From: Maria Tomalova [REDACTED]
Sent: 22 November 2021 15:37
To: [REDACTED]
Subject: RE: BR/119/21/PL - 73 & 75 Aldwick Road (Amended plans for comment)

From: [REDACTED]
Sent: 08 November 2021 10:36
To: Maria Tomalova [REDACTED]
Subject: BR/119/21/PL - 73 & 75 Aldwick Road (Amended plans for comment)

Component: **Proposed East Elevation**

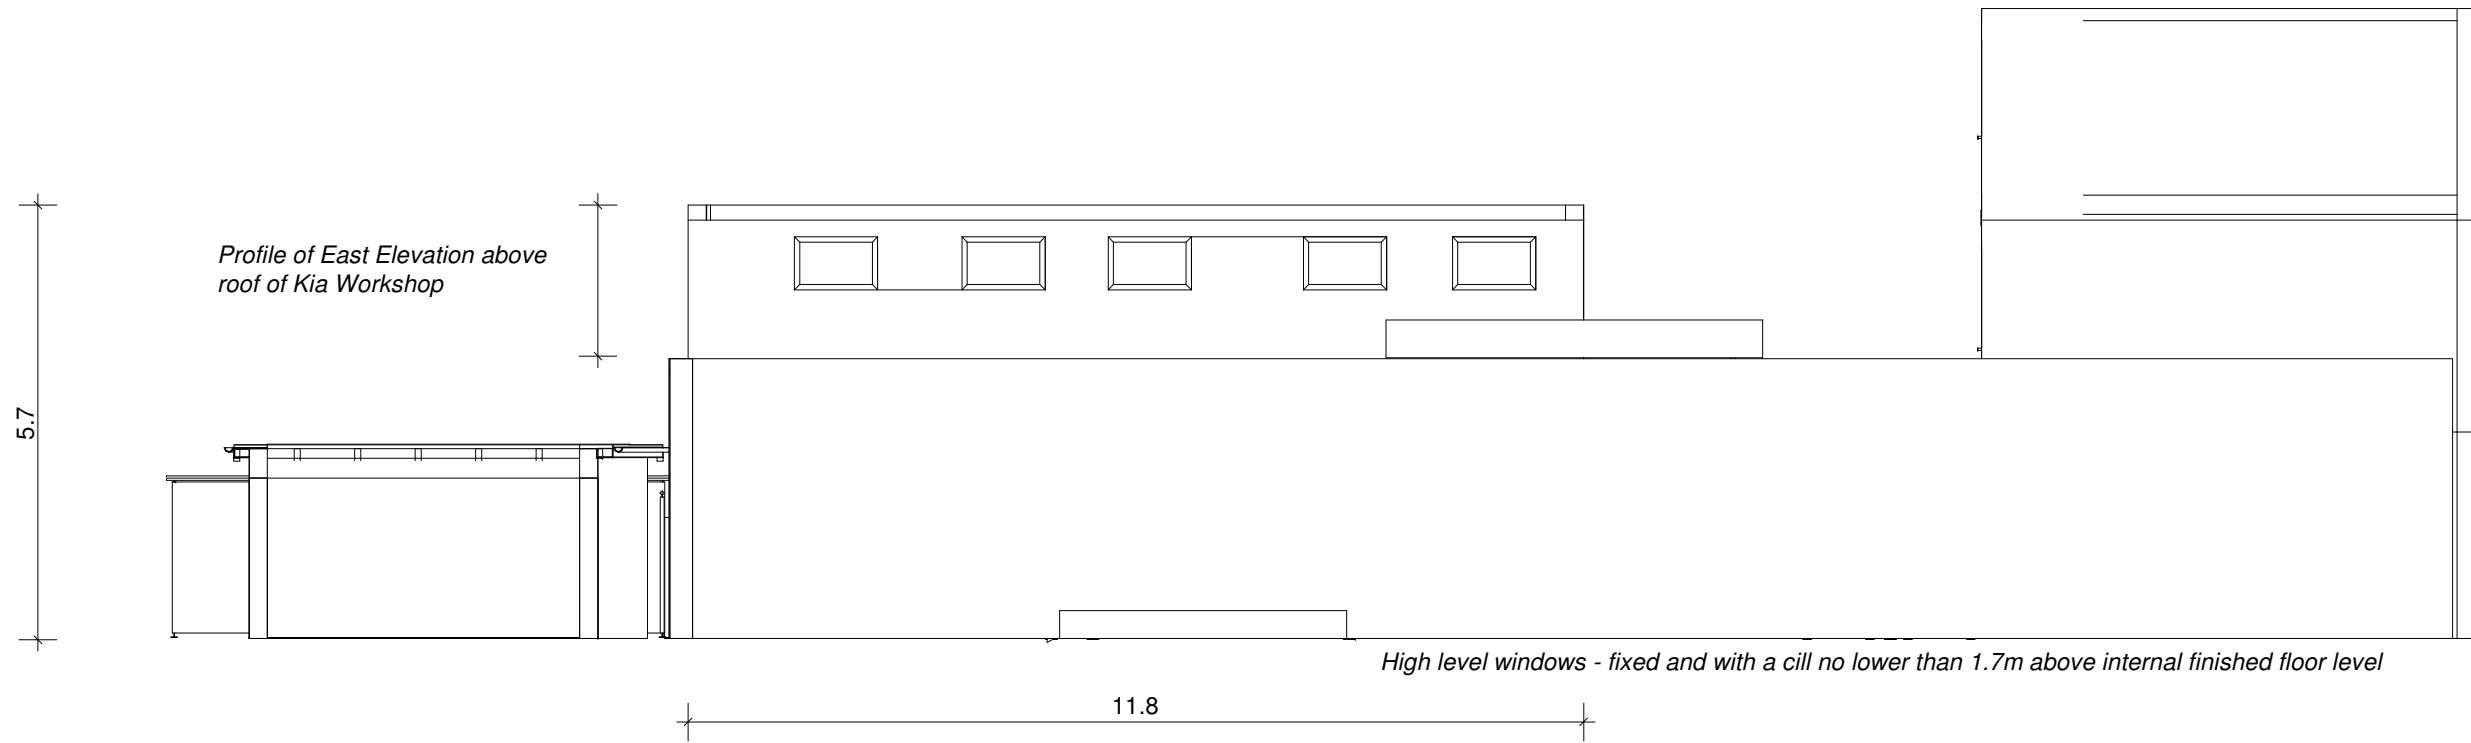
Is the parapet wall necessary ? (the roof above 'mews').
